ABLE MARINE ENERGY PARK (MATERIAL CHANGE 2 – TR030006)

UPDATED ENVIRONMENTAL STATEMENT

CHAPTER 4: DESCRIPTION OF CHANGES TO DEVELOPMENT & ALTERNATIVES

SLR Ref: 416.01148.00005
Version No: FINAL
June 2021

Scale: 1:50000A1  
 Drawn By: D Almeida  
 Checked By: R Crum  
 Approved By: R Crum  
 Date: 03/12/2020  
 Drawing No: AME-036-00001  
 Revision: D

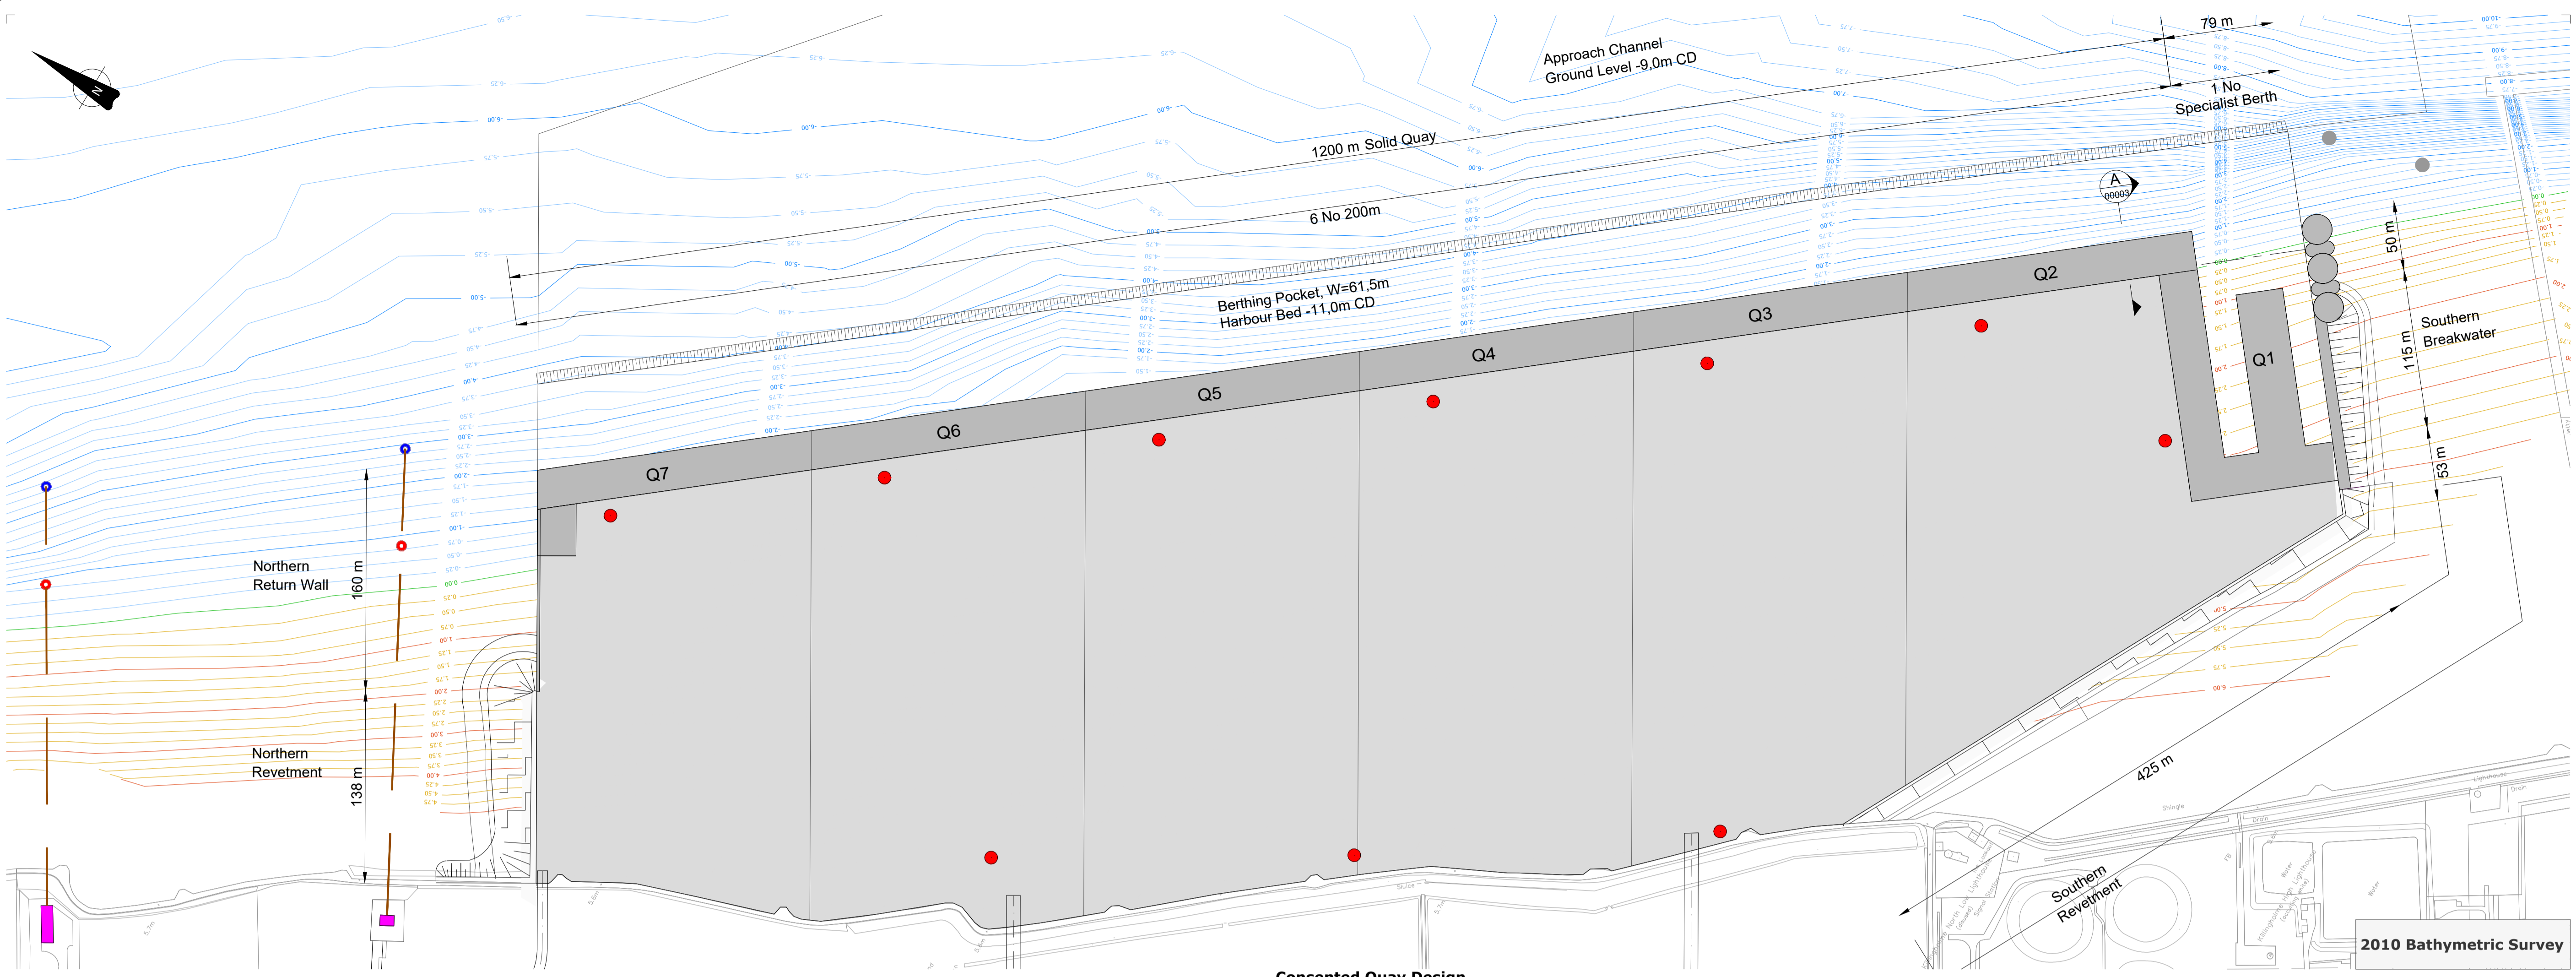
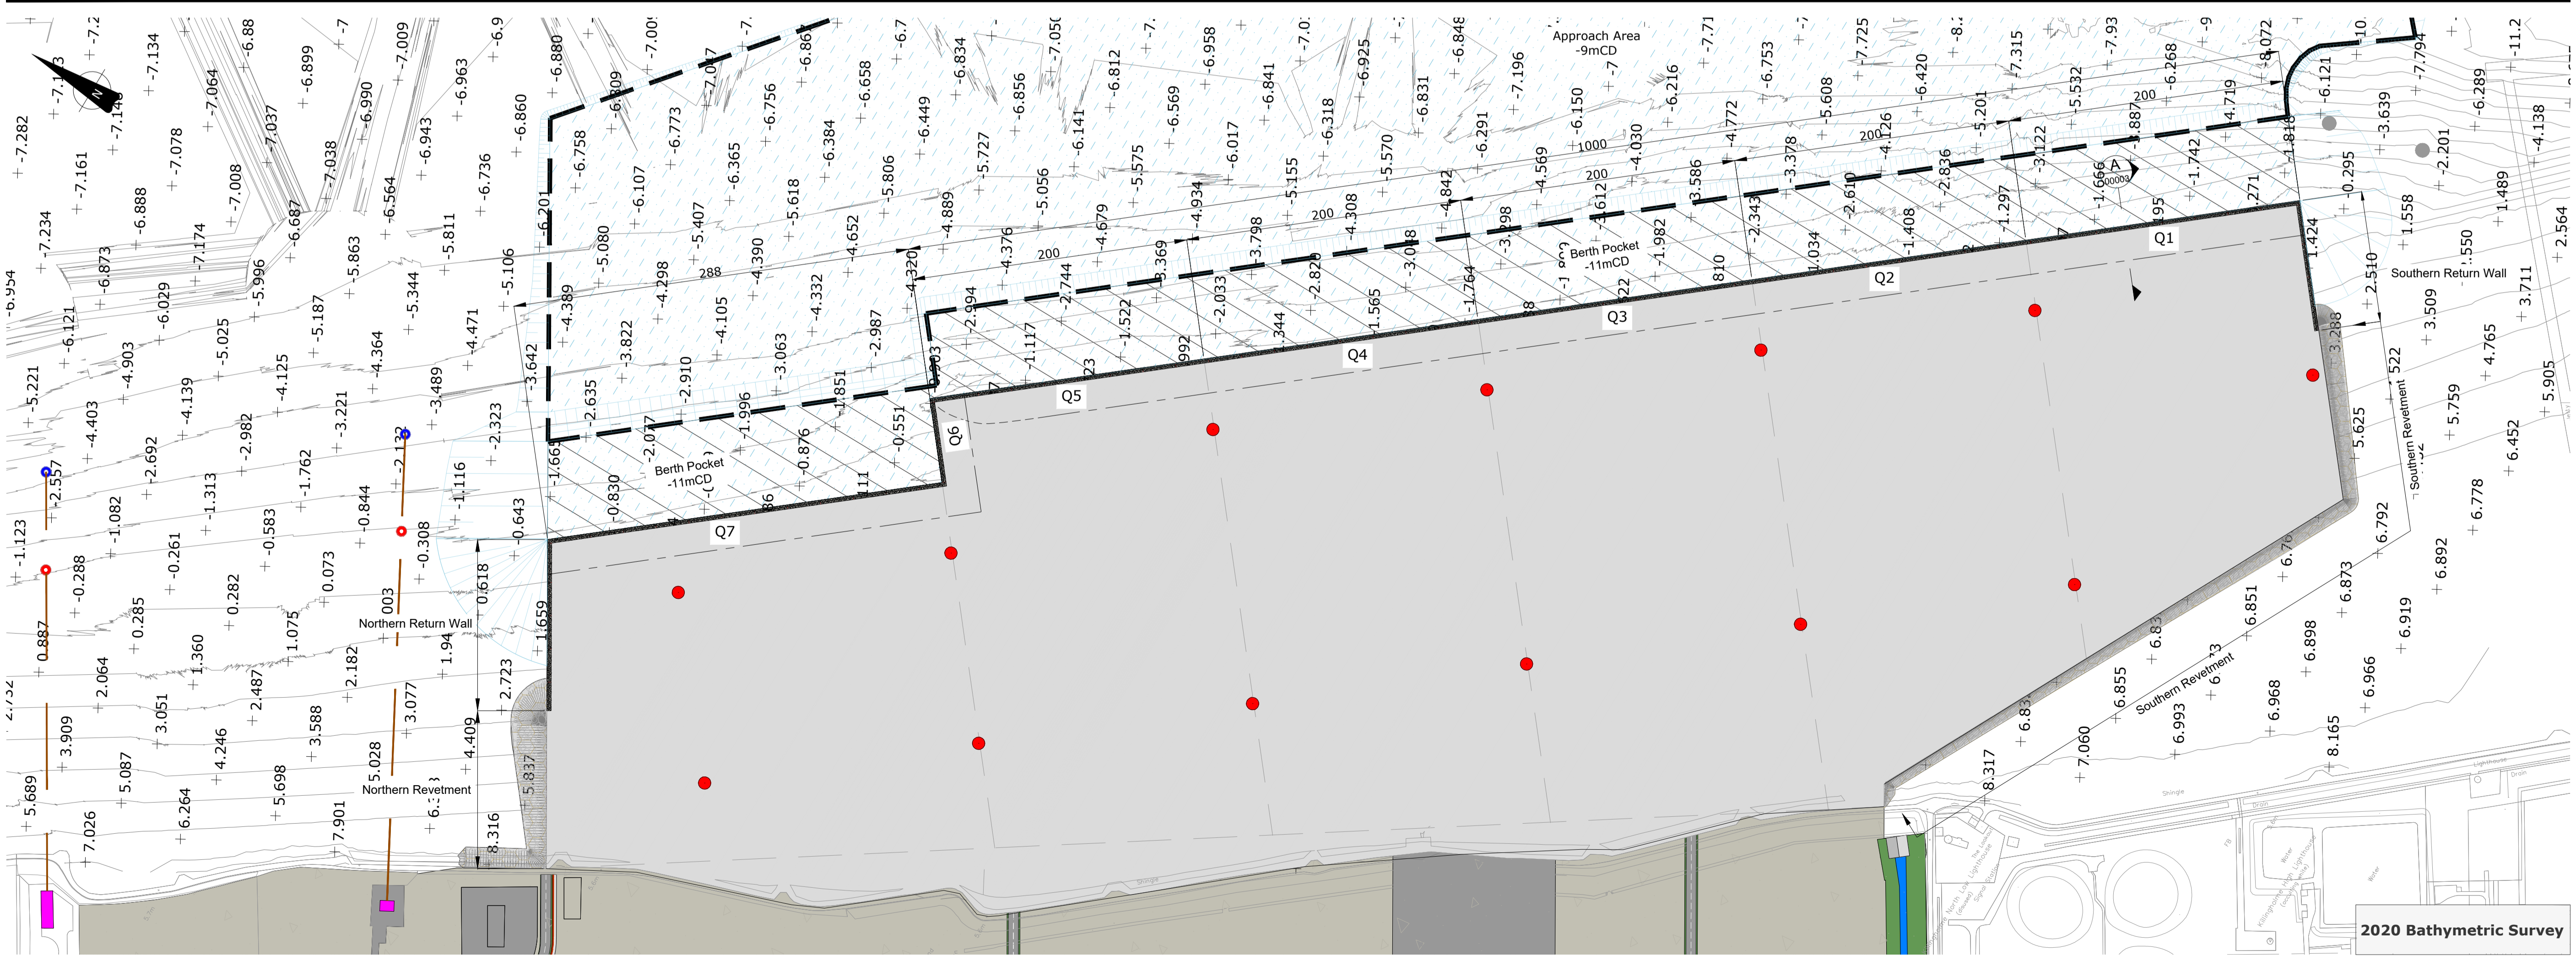
- 4.3.4 The net effect of changes (a) and (b) above is that marginally less land would be reclaimed from the estuary, refer to Figure 4-2. Nevertheless, no changes are proposed to the compensation proposals taken into account in the Secretary of State's Habitats Regulations Assessment for the consented development⁹. The change in habitat loss is summarised in Table 4-3 below, and the amendment results in a net reduction in the footprint of the quay from 45ha to 43.6ha. The changes are further

detailed on drawings AME-036-00001 - 00002 at Appendix UES4-1.
